Preferred Project Report (Revised) for

Major Project Application No. MP09-0166 for Altitude Aspire, Terranora

Submitted to
Newland Developers Pty Ltd
April 2013

Title:	Revised Preferred Project Report
Author(s):	B. Lees and D. Holstein
Status:	Issue 1 – Revised PPR
Client:	Newland Developers Pty Ltd
Application No:	09_0166
Synopsis:	This Preferred Project Report (PPR) addresses the issues the Department of Planning (DoP) and Tweed Shire Council (TSC) have identified as requiring resolution, confirmation and/or clarification from the original Preferred Project Report (PPR) for a proposed development designated as 'Altitude Aspire' which forms part of the overall proposed development of land identified in TSC's Residential Development Strategy as 'Area E', located at Terranora NSW. The submissions made to the DoP during exhibition of the Environmental Assessment (EA) of the proposed 'Altitude Aspire' development with consideration to TSC Development Control Plan DCP B24, and the engineering criteria listed in A5 of the Tweed DCP have been specifically addressed within the report. The Revised PPR continues to establish the basis on which the development may be serviced with the rel

TERRANORA PRECINCT 1
WATER QUALITY TREATMENT AREAS

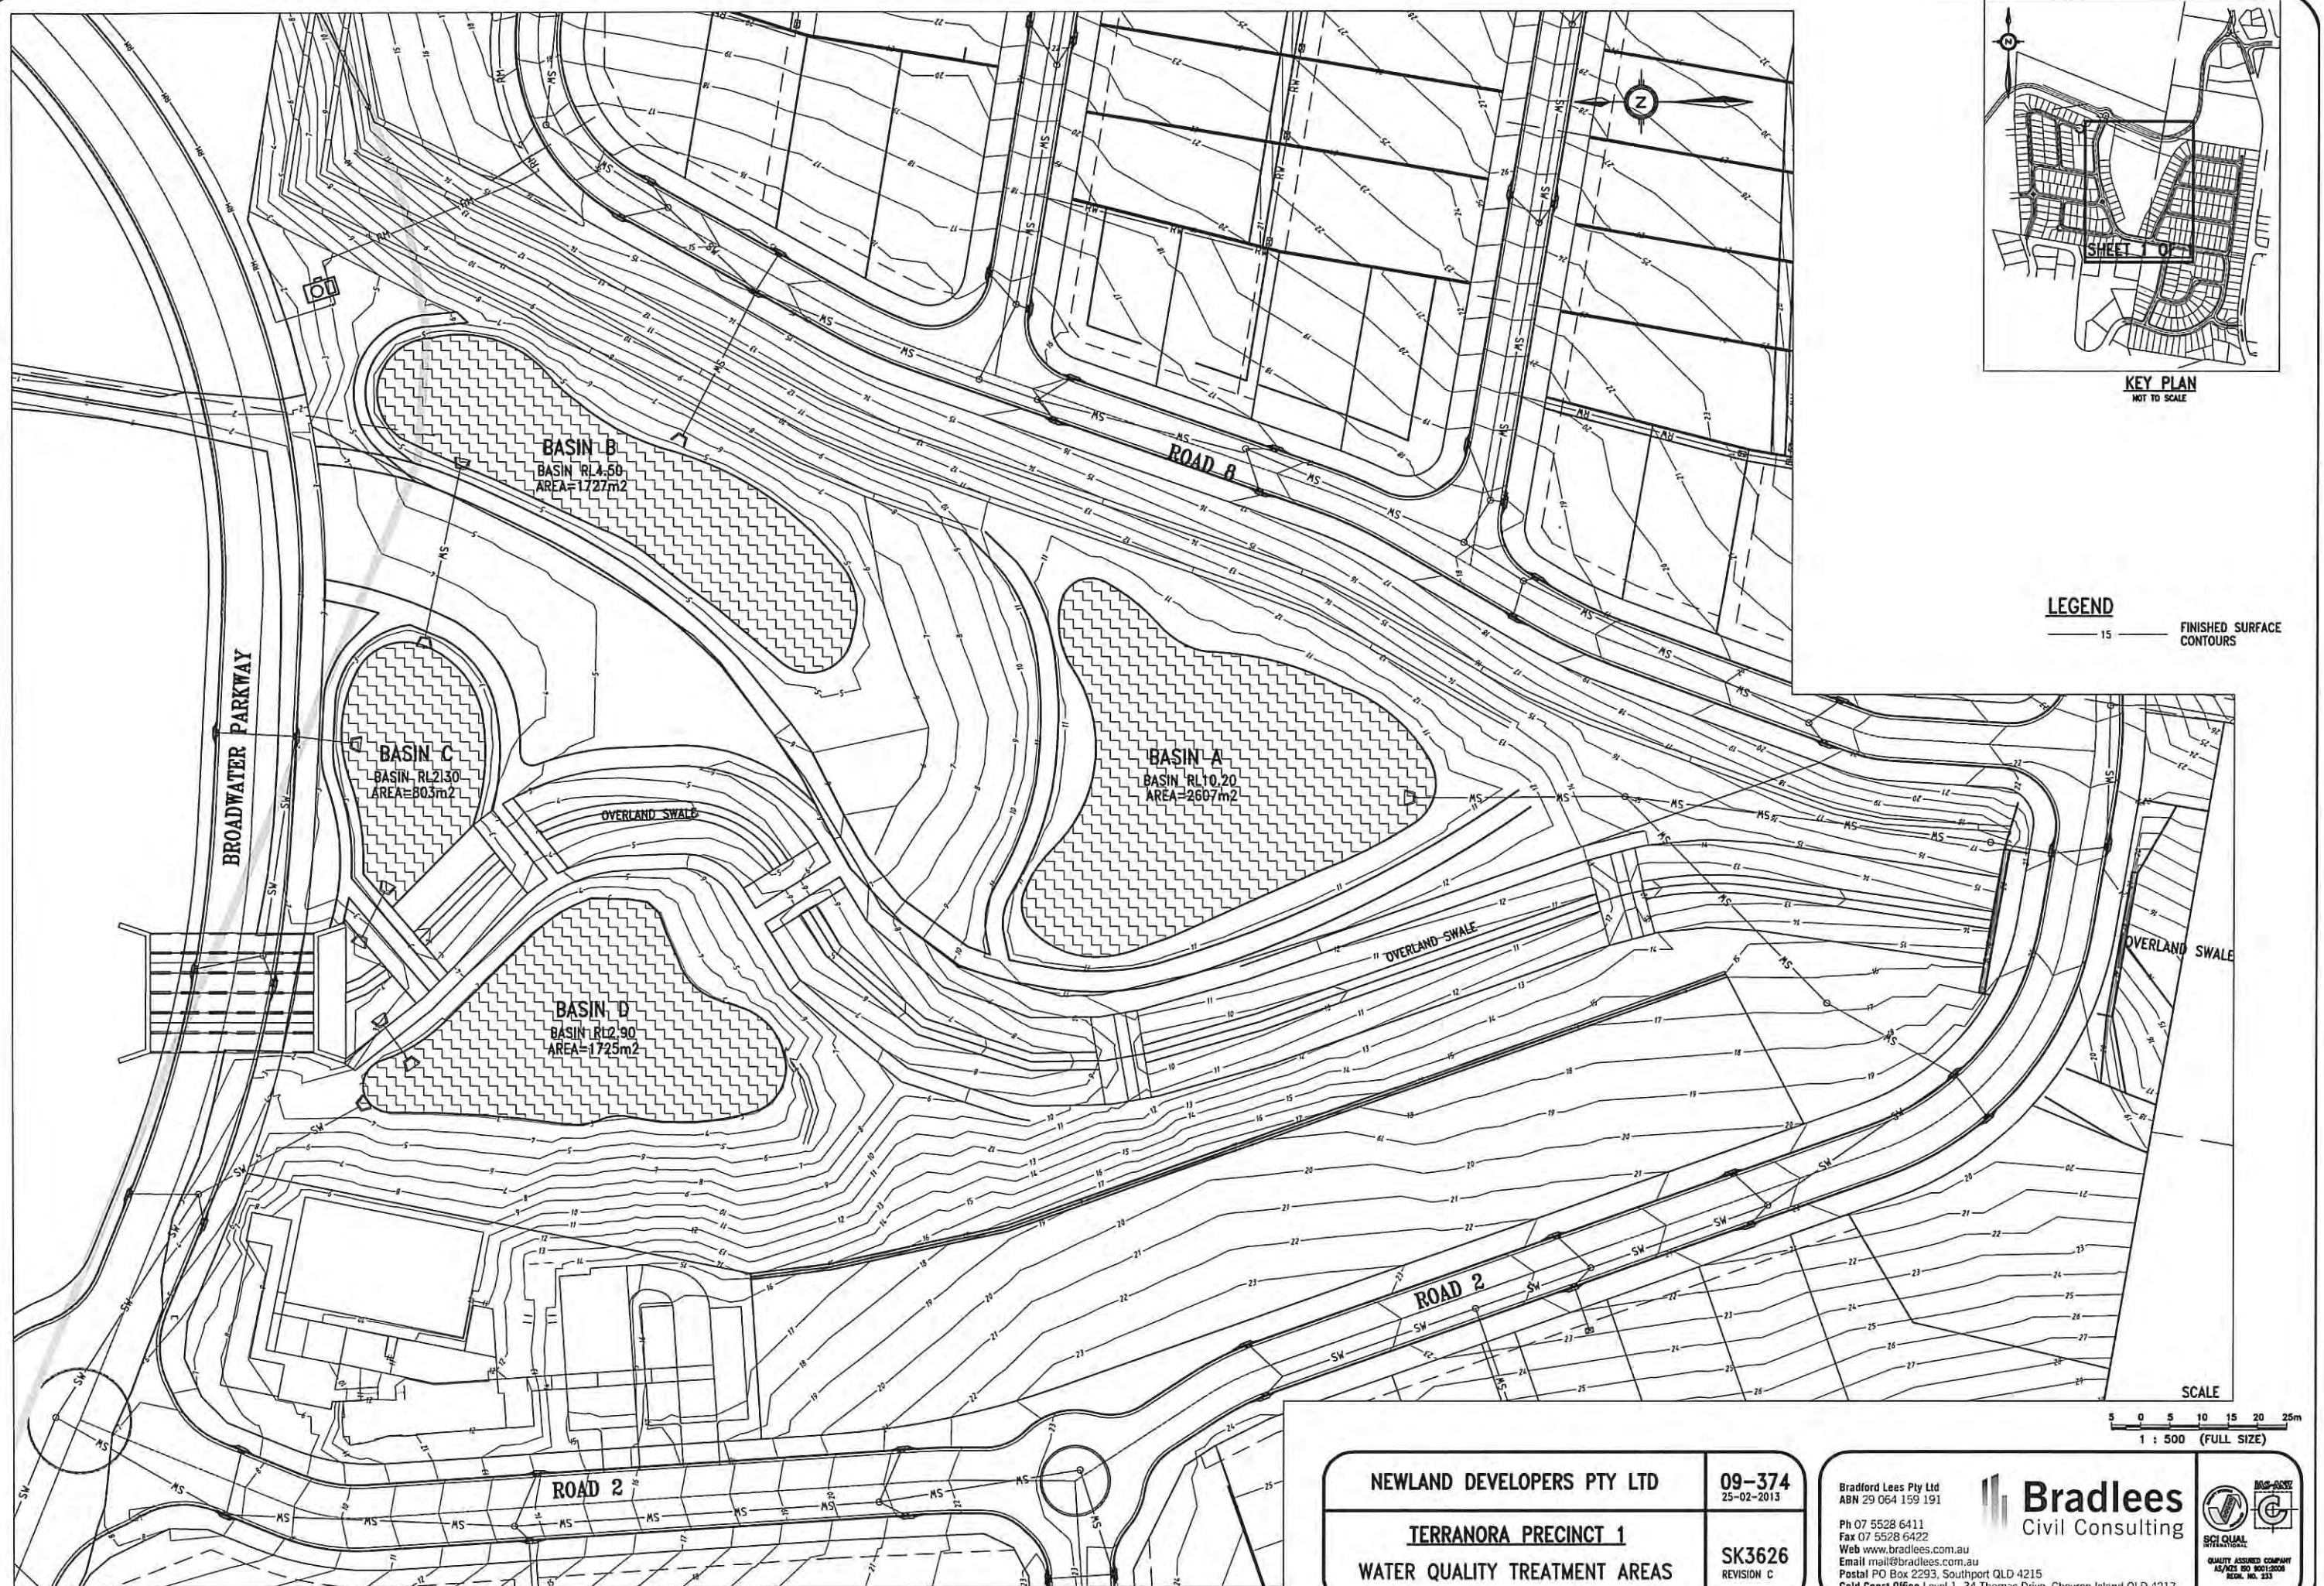
Council requests all lots between Roads 2 and 5B be deleted and reduce fill within the gully line.	Lots have been deleted from this area.	Appendix 1 – Proposed Subdivision Plan
		The department does not support location of artificial wetland on existing natural wetland areas. An alternative site upstream of proposed location, or an alternative method for stormwater treatment must be provided.	Bio-retention basins now proposed – these basins will be sited on the upstream side of the Broadwater Parkway.	Section 3 – DGR 4.1 (c) & Appendix 6 – Stormwater Layout Plan
Stormwater	TSC	Stormwater catchments size must be consistent between SWMP and Engineering report.	Noted	N/A

NEWLAND DEVELOPERS PTY LTD	09-374 24-02-2012
TERRANORA PRECINCT 1 ROAD 1 - FRASER DRV. INTERSECTION LAYOUT	SK 3646 REVISION A

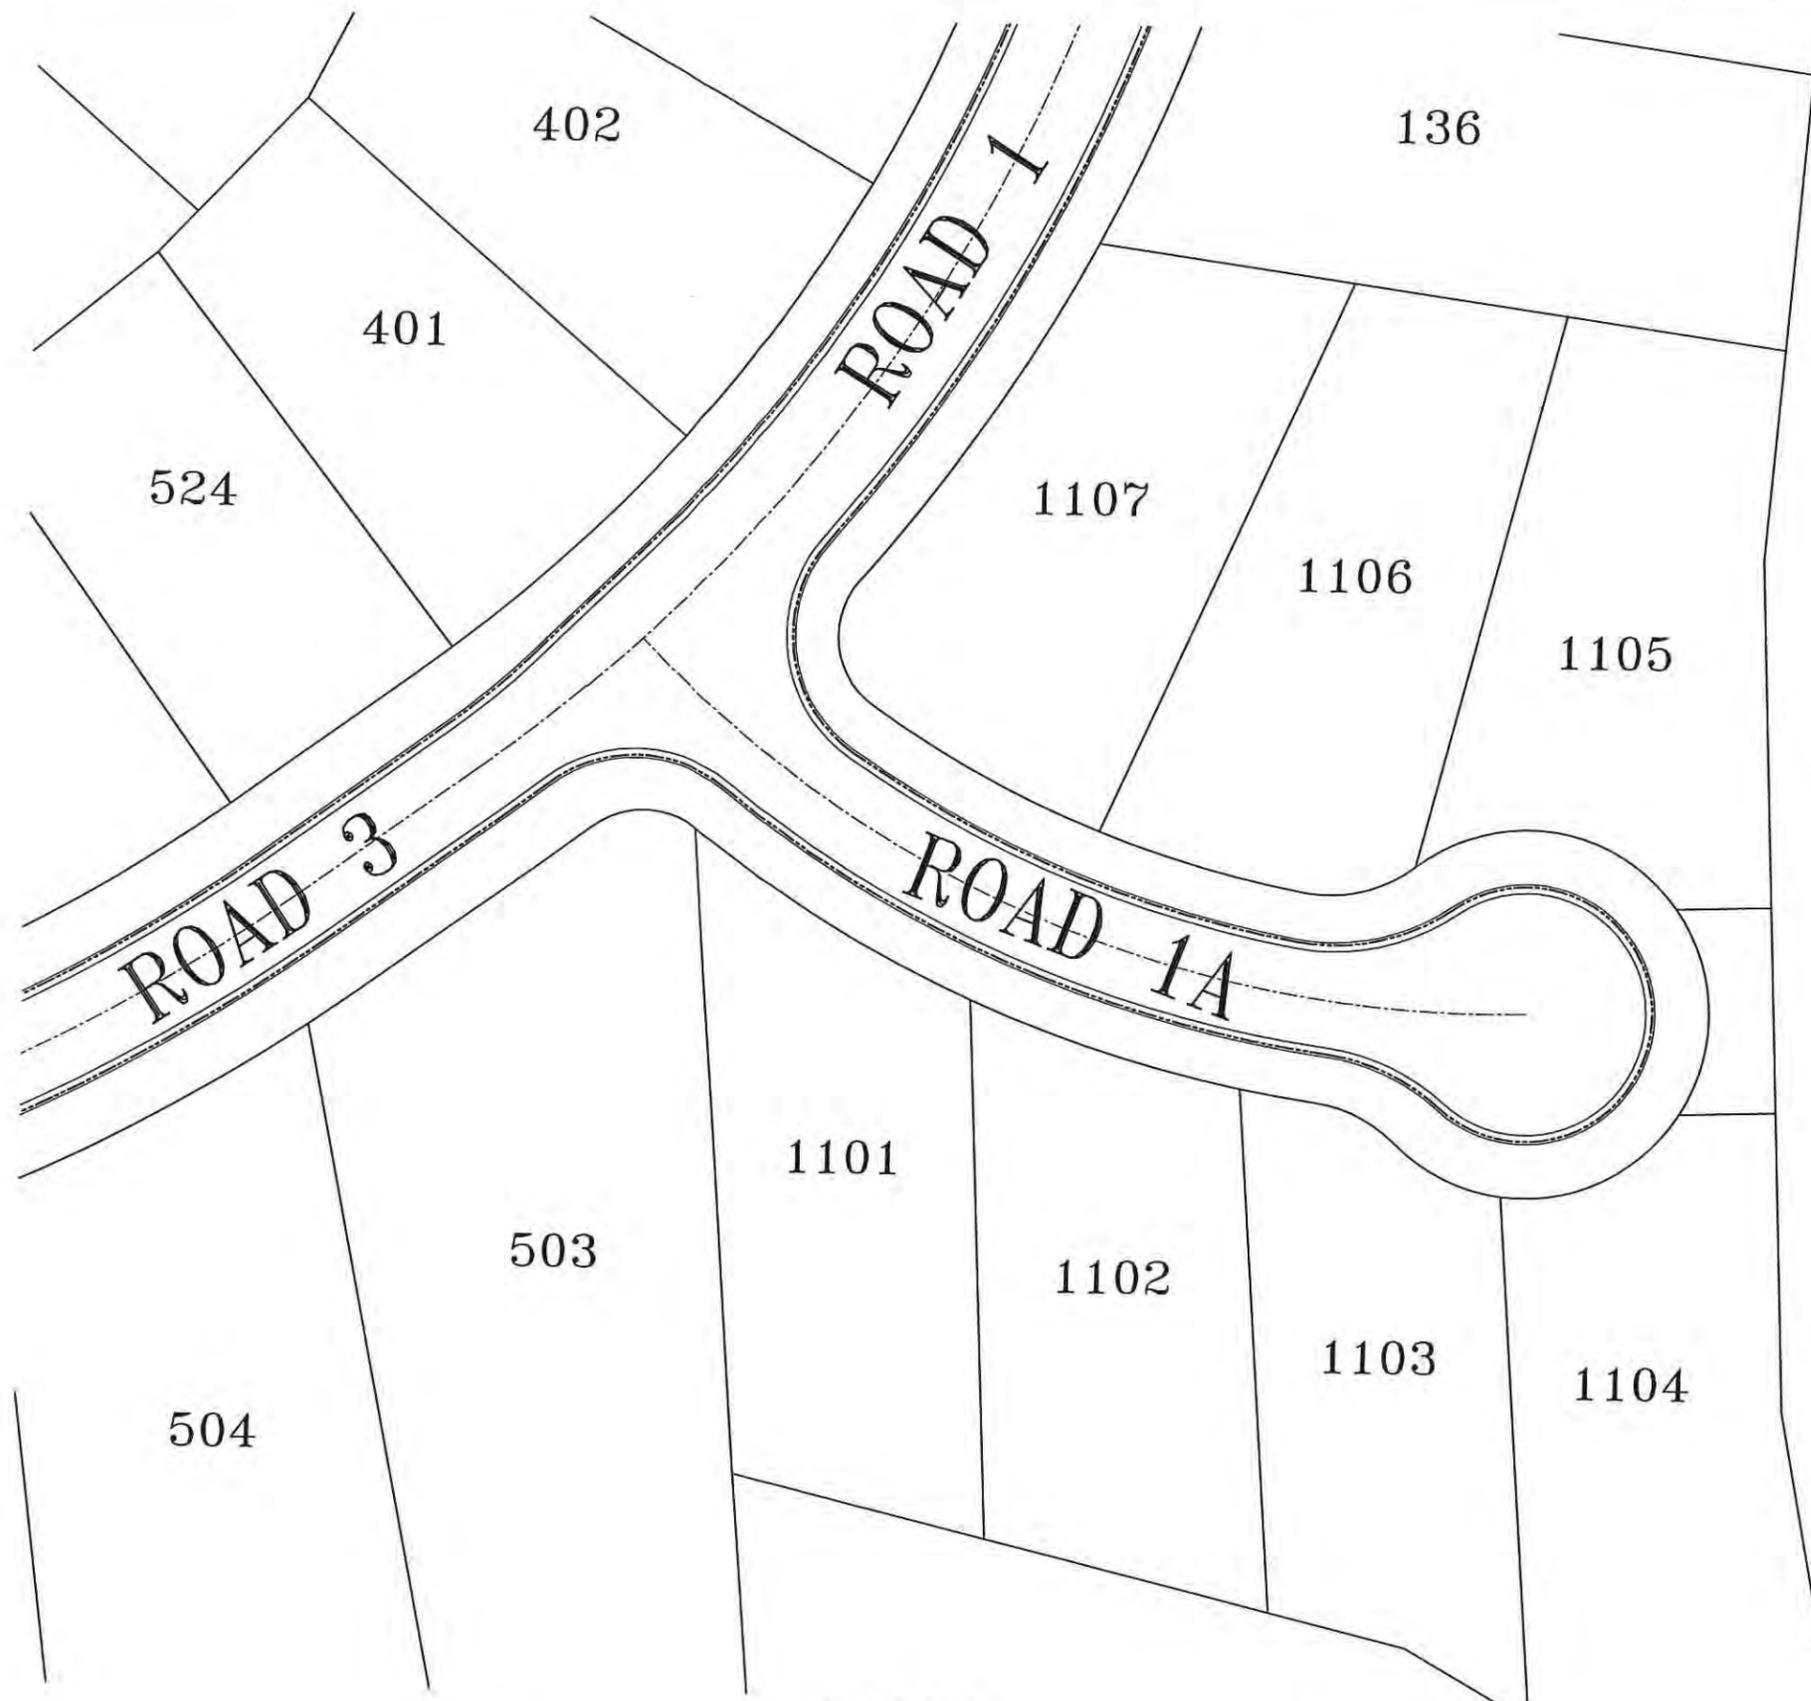
The design of the internal T-intersection, where the connection road from Fraser Drive meets the main internal road in Stage 4 requires either: 1. A priority route realignment to minimise potential vehicle collision, or 2. A roundabout at the intersection of the connection road from Fraser Drive and the main internal road in Stage 4	The intersection of Road 1 and Road 3 has been revised to provide priority to vehicles travelling on Road 1	Section 2.2 & Appendix 3
	Roads and Traffic Authority	It is suggested that roundabout control be considered for the 'temporary' connection to Fraser Drive to reduce the extent of impact on existing properties opposite this intersection.	Intersection has been revised and remains a priority 'T' based on advice from Traffic Engineers	Section 2.2 & Appendix 4
